# CITY OF ALBUQUERQUE

February 15, 2012

**Re: Lowes Subdivision Lot 3  
Grading and Drainage Plan  
Engineer's Stamp dated 2-8-12 (A14/D006B)**

OFF-SITE STORM DRAIN INLETS

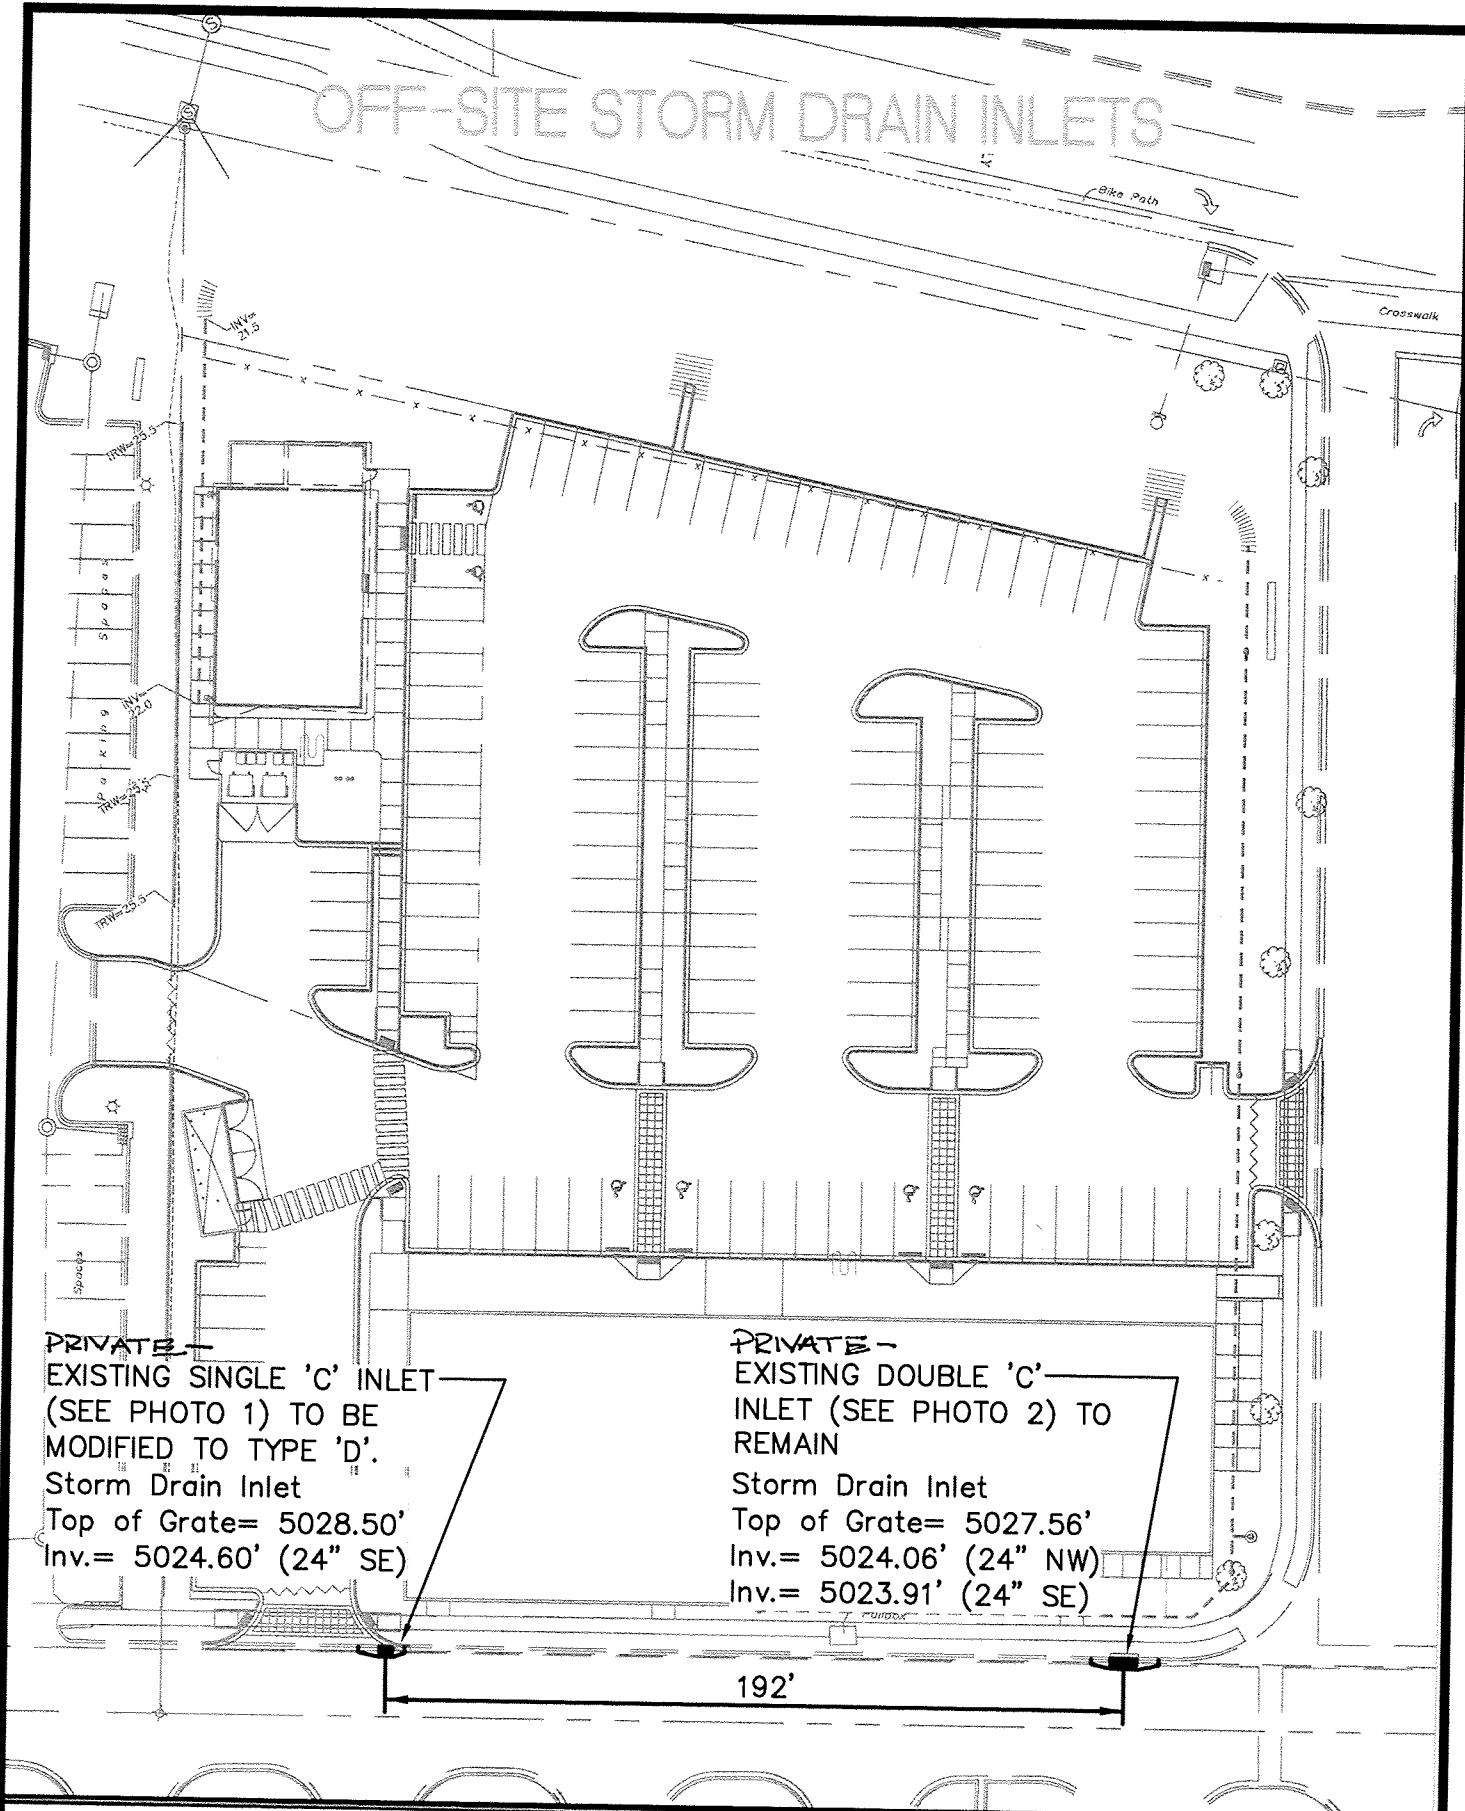
- Provide an analysis showing that the replacement of the "C" inlet with a "D" Inlet will not cause an unacceptable amount of bypass flow with a 50% clogging factor or can the inlet be moved to the east?

GRADING AND DRAINAGE PLAN

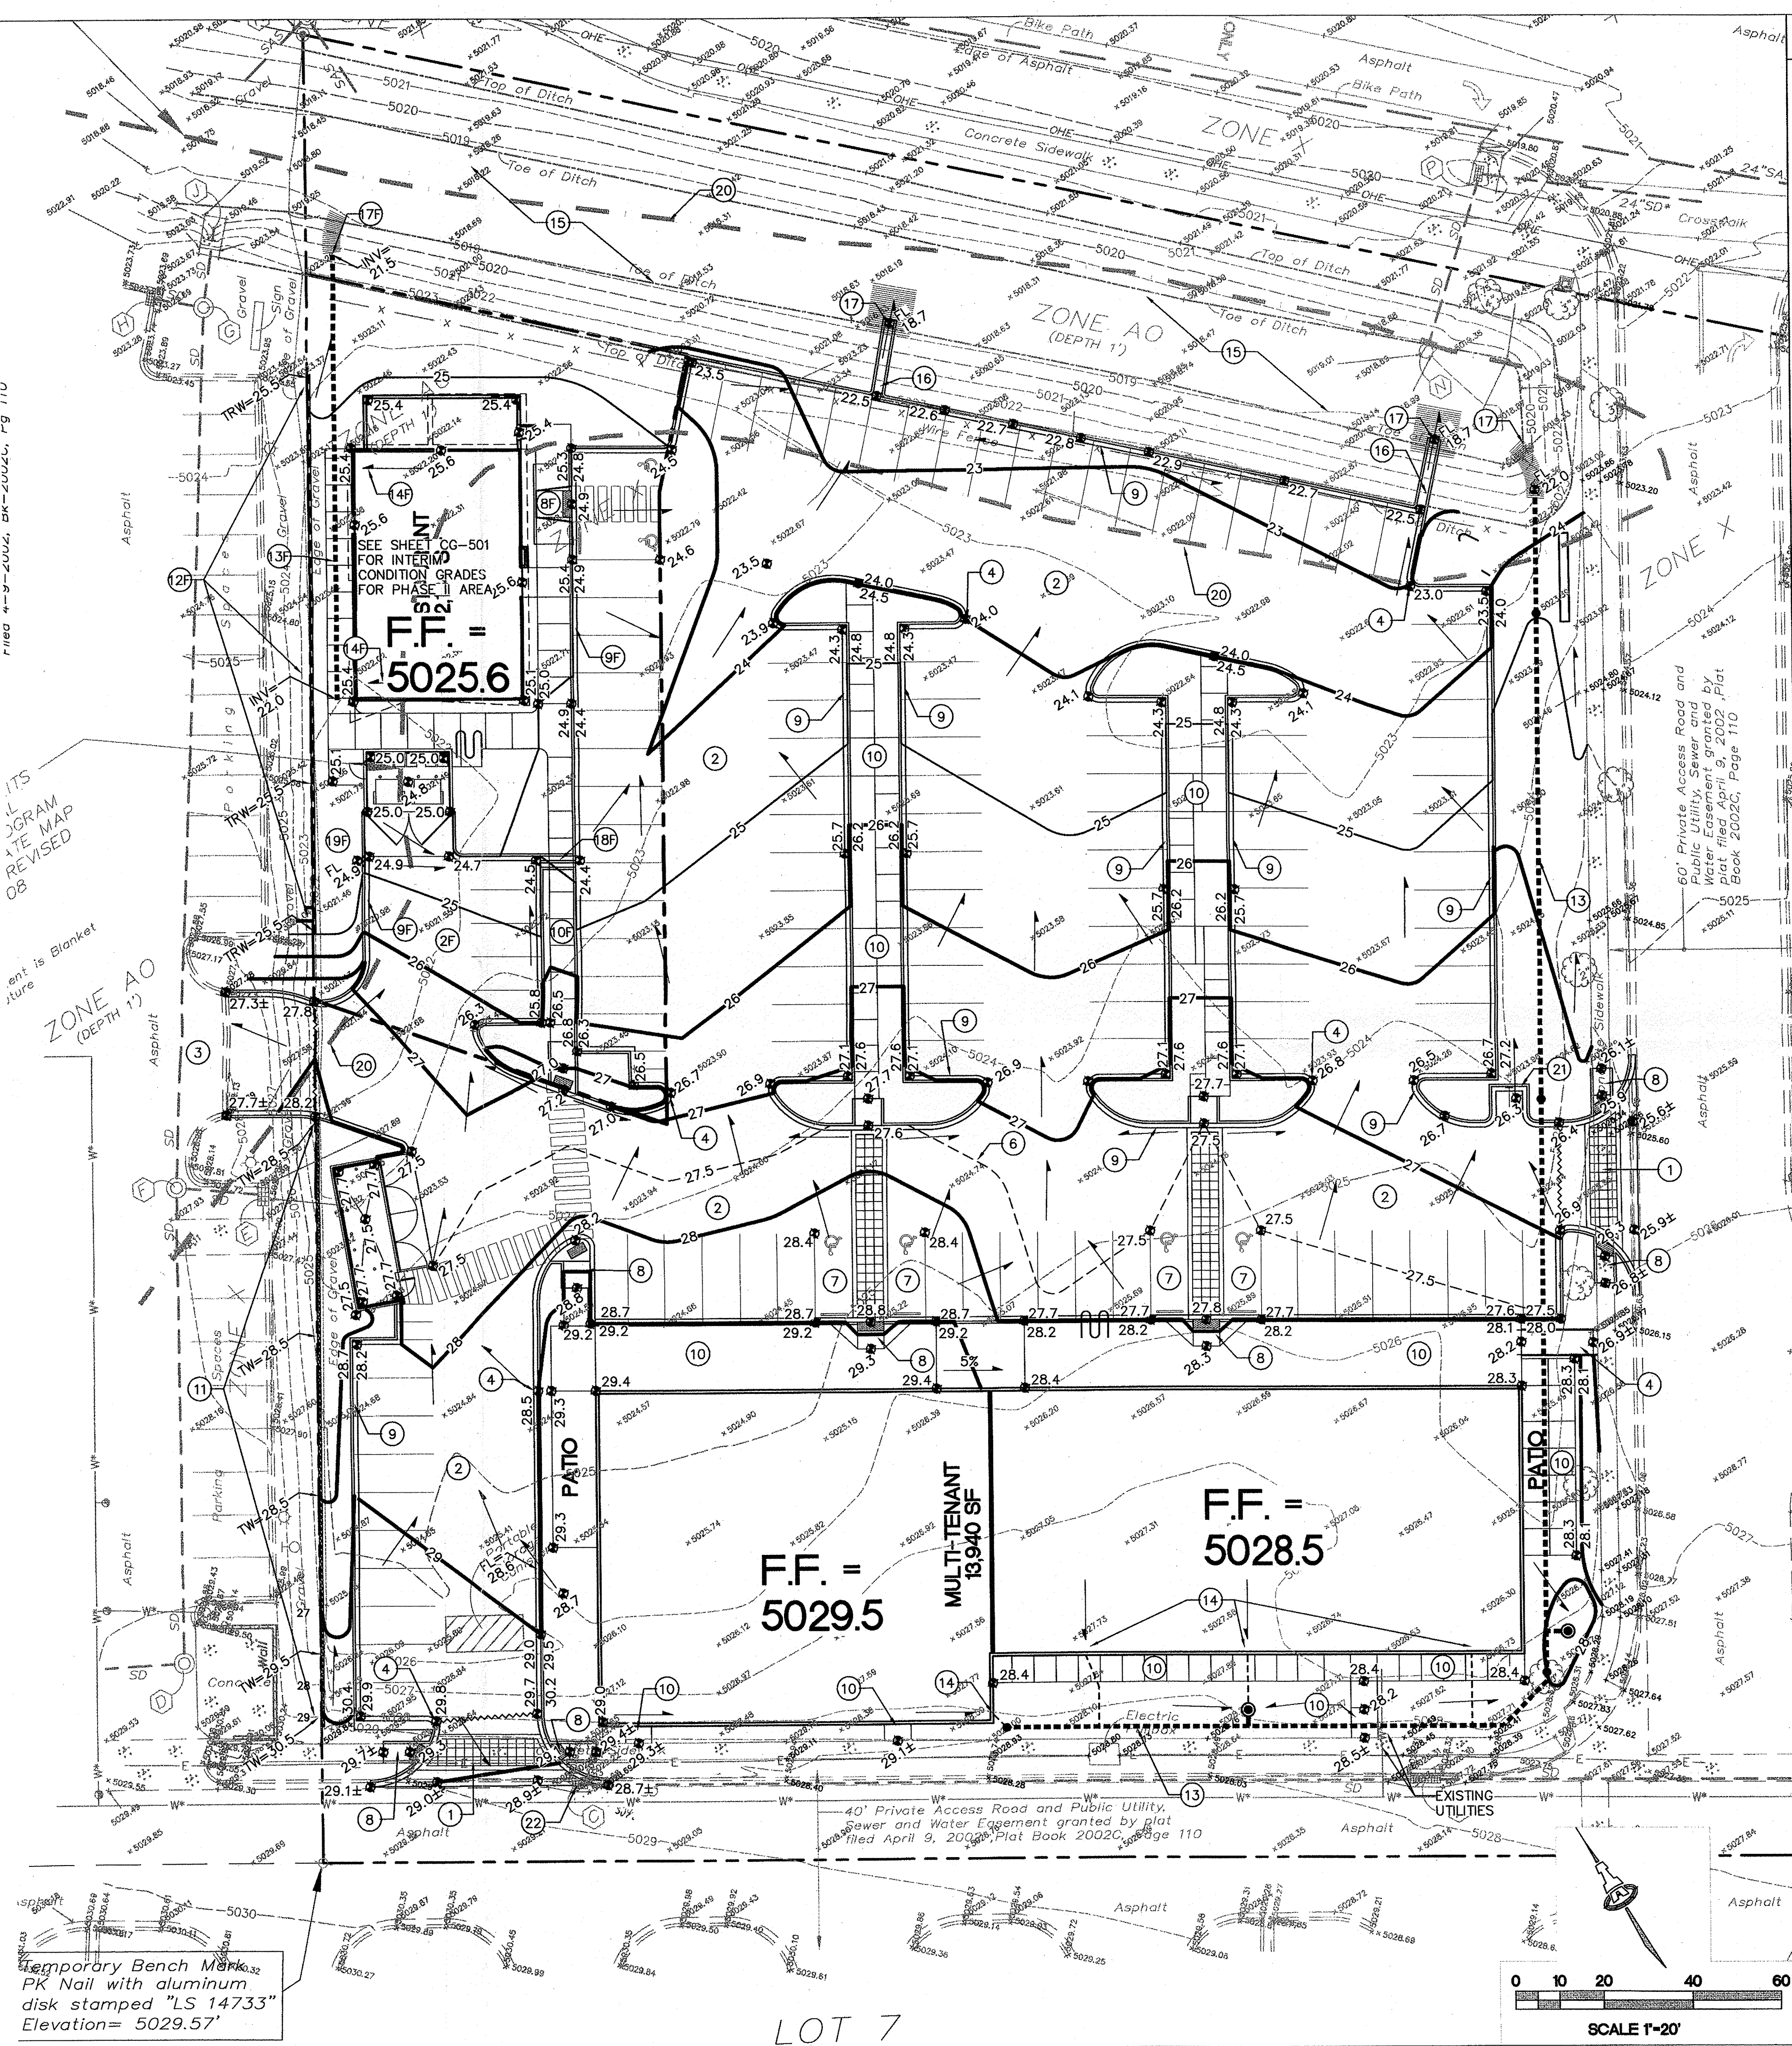
Hydrology is requesting that all proposed landscape areas are depressed to retain/infiltrate the moisture that falls on them.
